# Land at Ford Airfield, Ford, West Sussex

## RM4 (F/16/24/RES)

Design Advisor Response, 01.11.2024

PHASE 4 THE LANDINGS, FORD, WEST SUSSEX
PROPOSED HOUSETYPE PLANS - HT "354" VARIANT "V7"

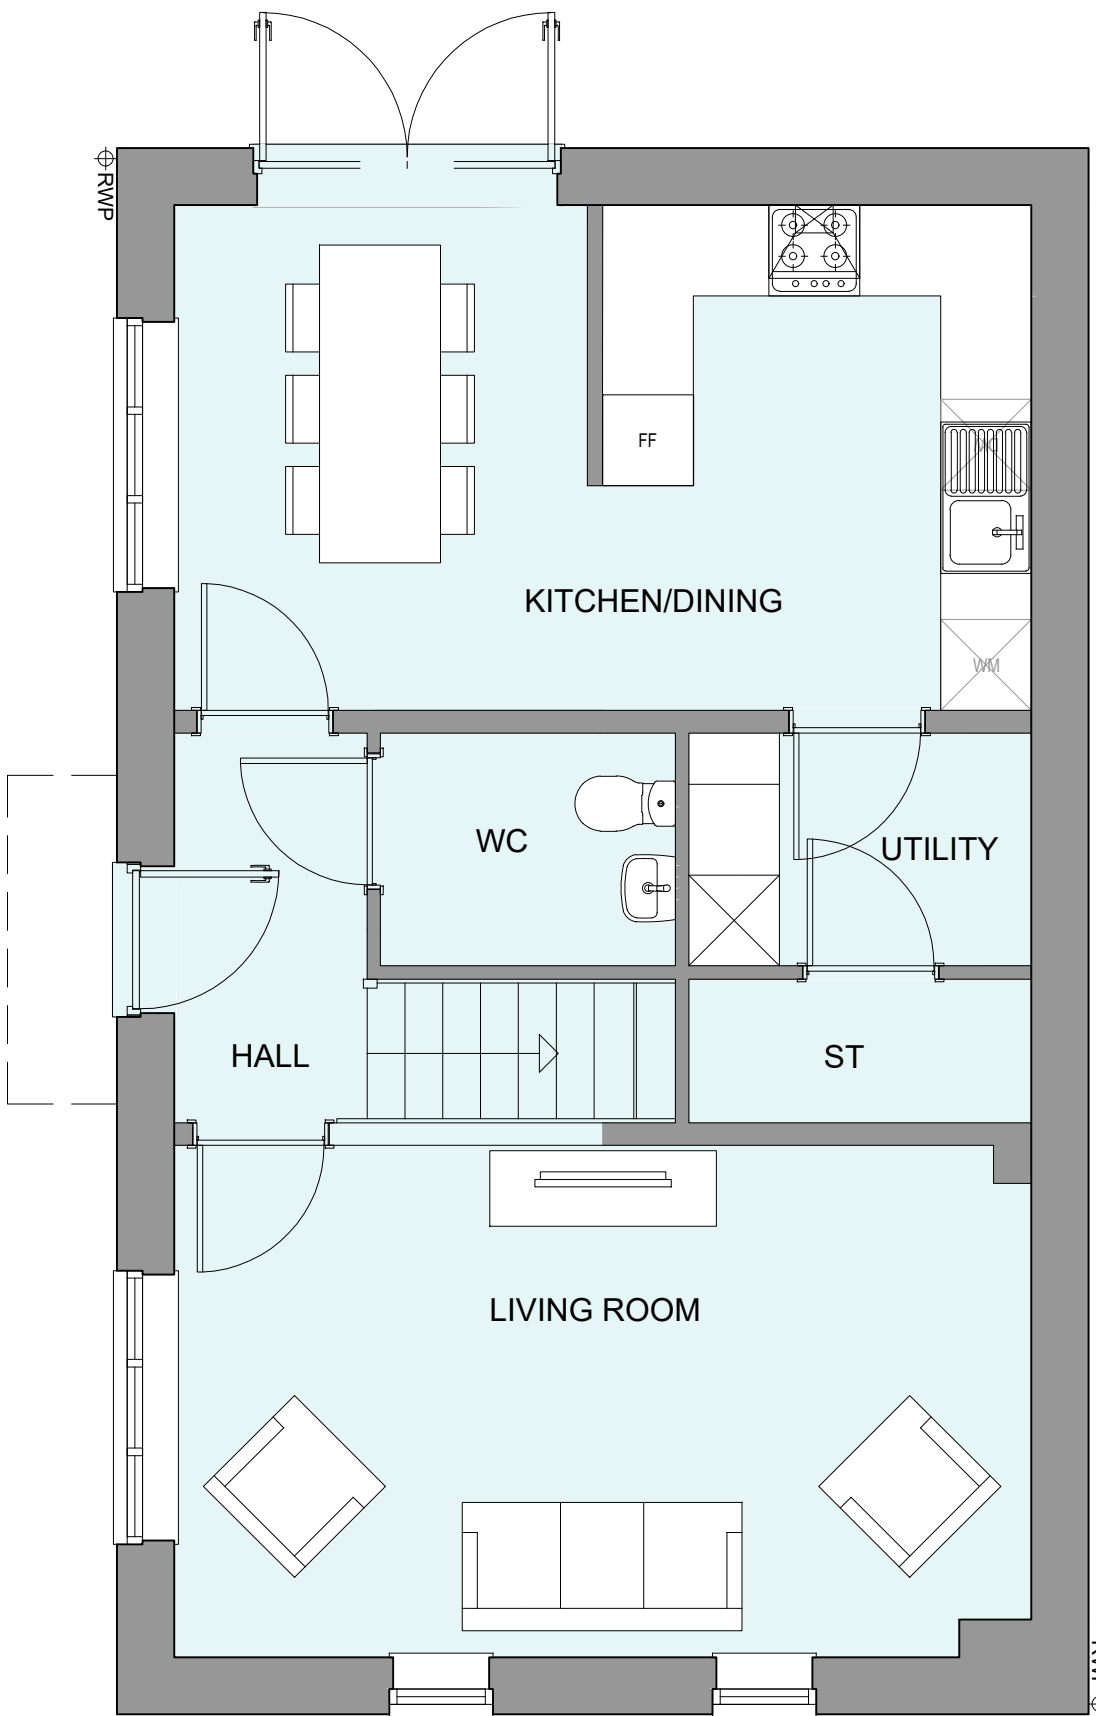
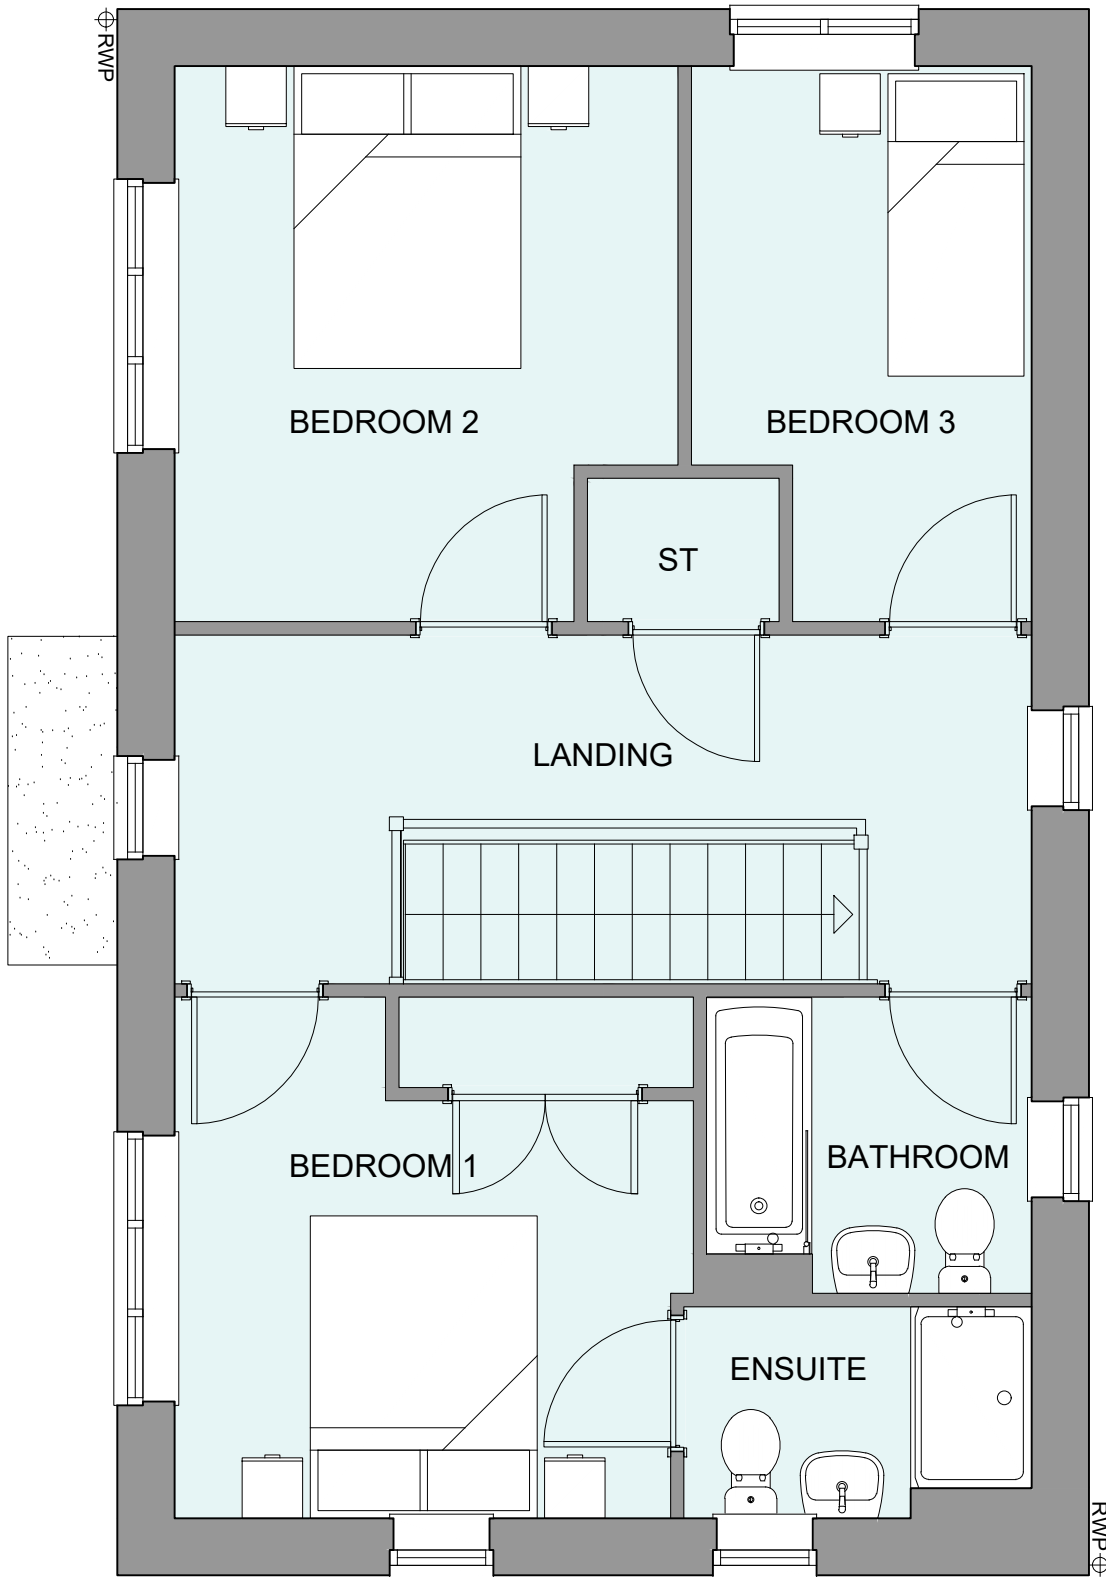
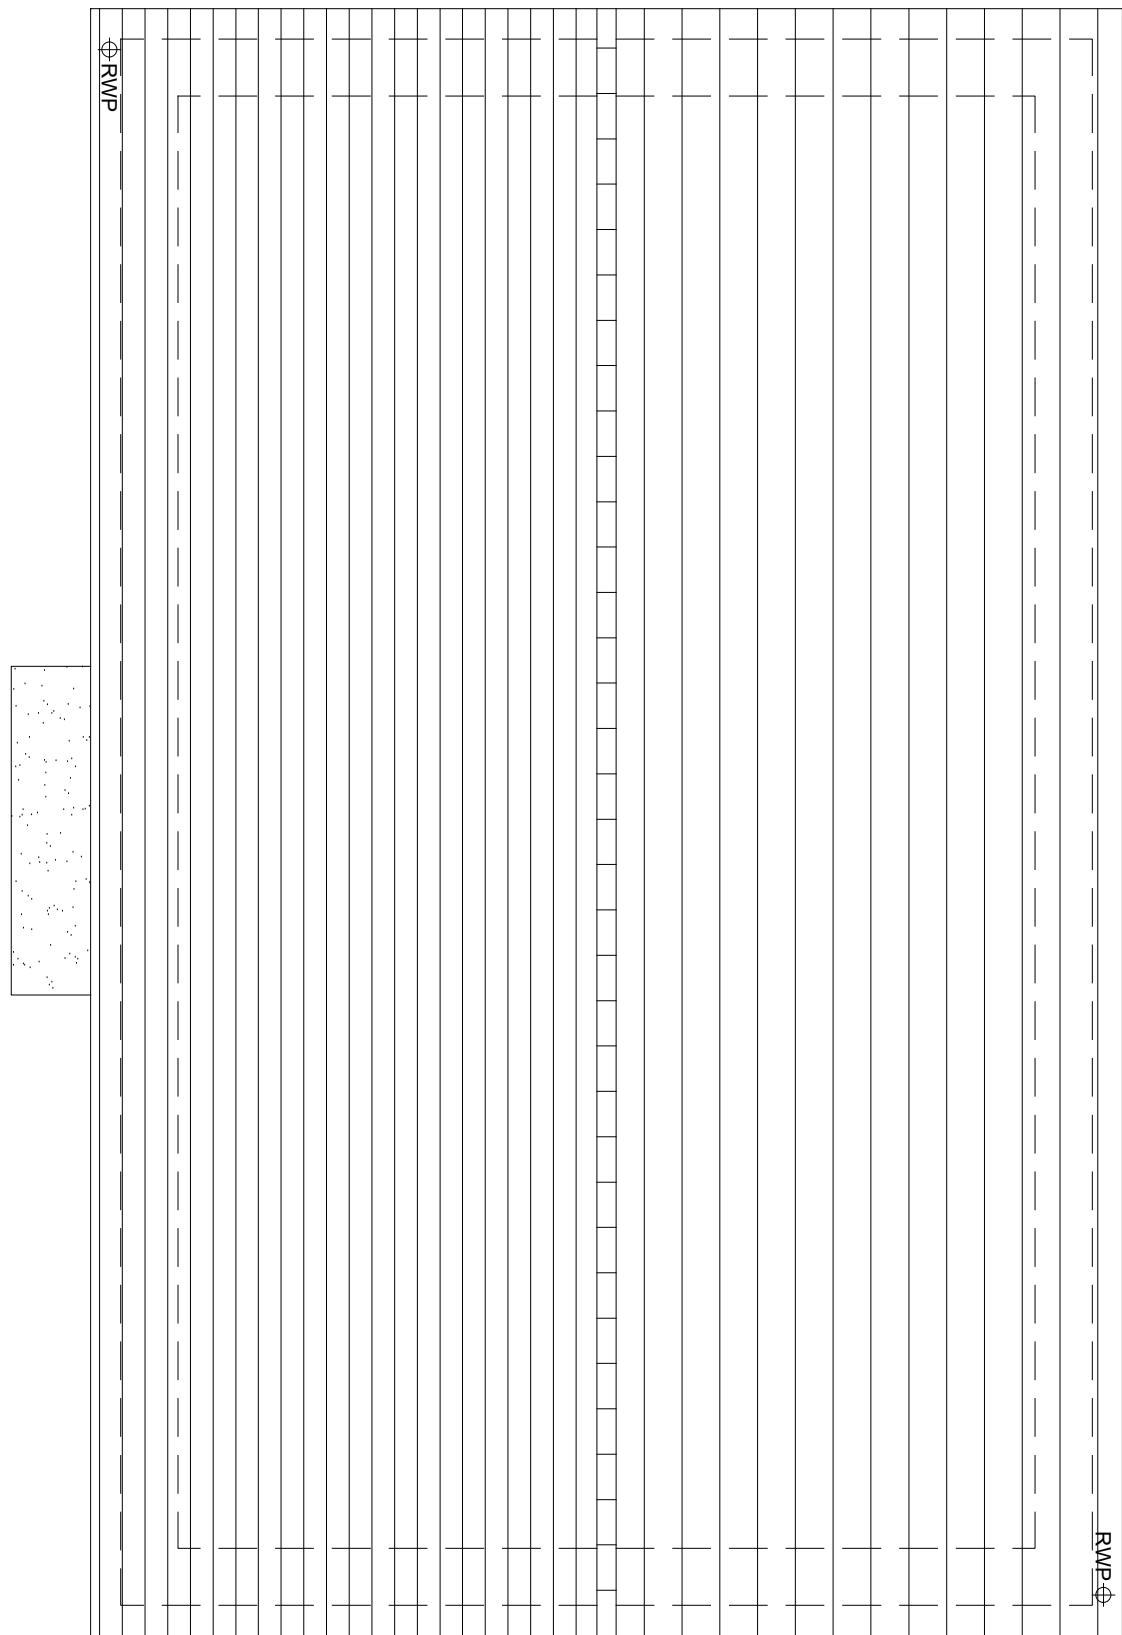
4.18. HT354-V7: similar to the previous comment, the height of the brick course creates a tension with the ground floor window, where there is only 100/ 150mm of render between the top of the brick and the underside of the sill.

PHASE 4 THE LANDINGS, FORD, WEST SUSSEX
PROPOSED HOUSETYPE PLANS & ELEVATIONS - HT "356" VARIANT "V8"

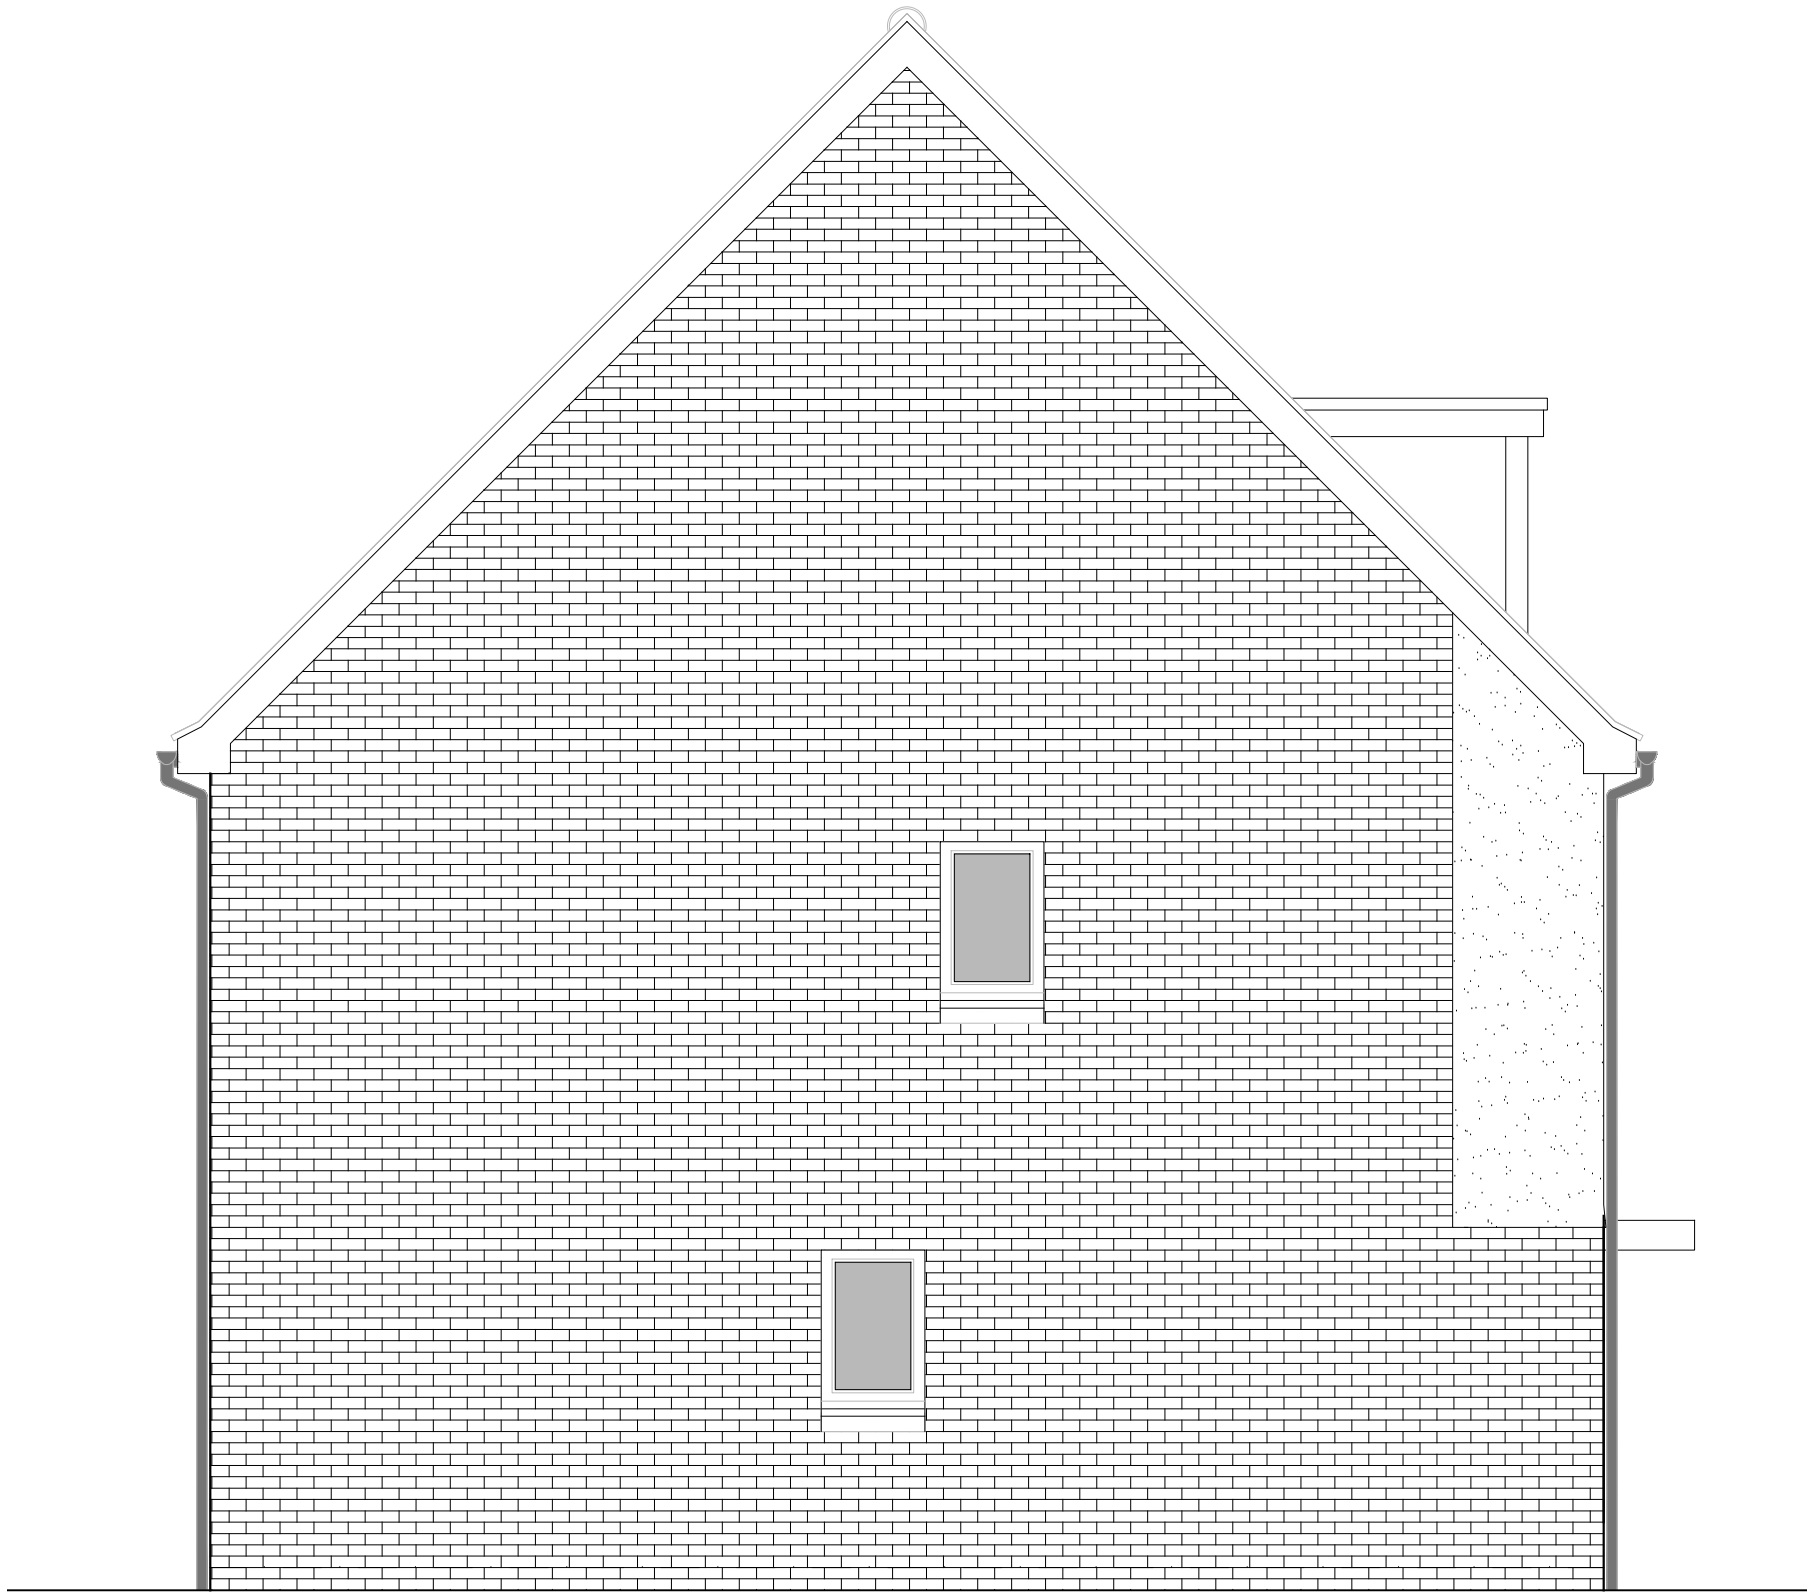
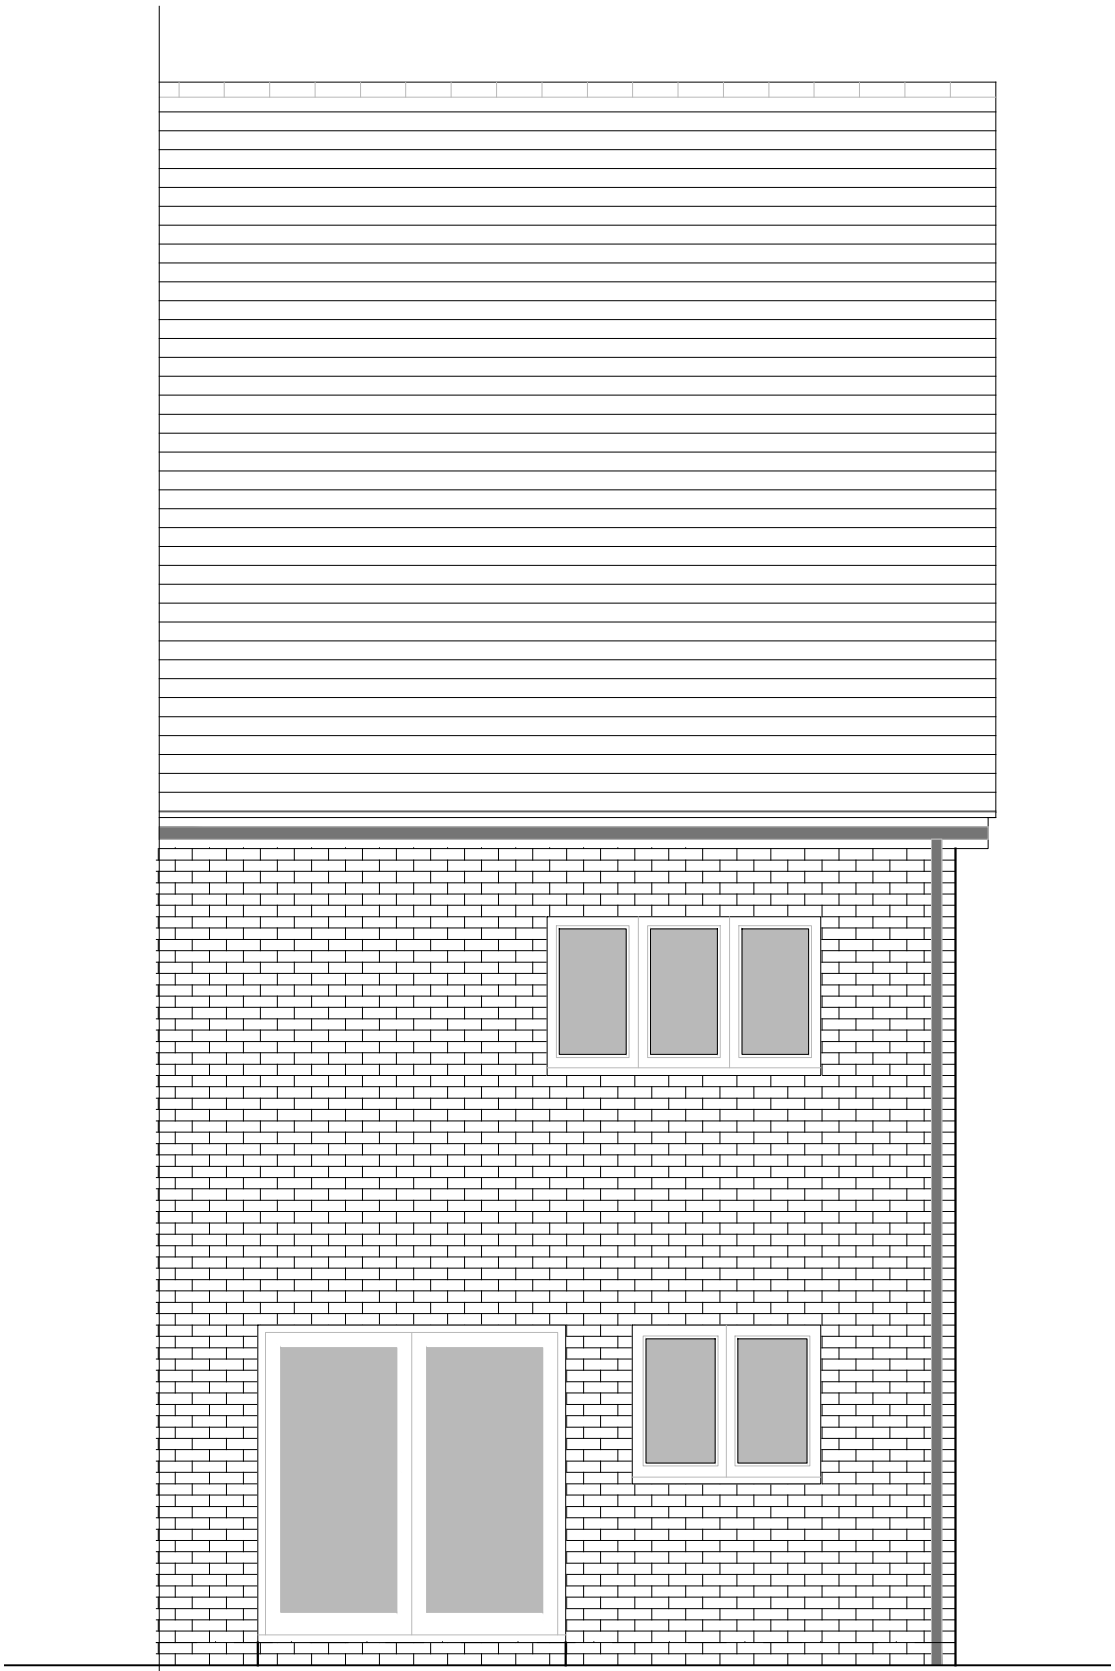
- 4.1. Type 354: no variant '3' or '13' (of 14).
- 4.2. Type 466: no variant '5' (of 6).
- 4.3. Almost half the elevation of type 356 is represented by the roof. A wider building might be able to balance this, but the proposed type is less than 5m wide. As such, the roof is considered to be dominant and the house type is not supported.
- 4.4. The length of the internal garage for type 468 is less than the DC's 6m minimum in order to count towards parking provision.
- 4.5. The length of the internal garage for type 463 is (slightly) less than the DC's 6m minimum in order to count towards parking provision.

4.7. HT356: while the roof pitch is shallower than HT236 (45 degrees compared to 51 degrees), because of the front-to-back pitch, the roof represents almost half of the elevation and the dominance is greater. Overall, a limited number of attached variants is considered to be acceptable, but detached versions would not (although it does not appear that any detached versions are proposed).

4.23. HT356: ideally, the window above the door would align with another element beneath this.
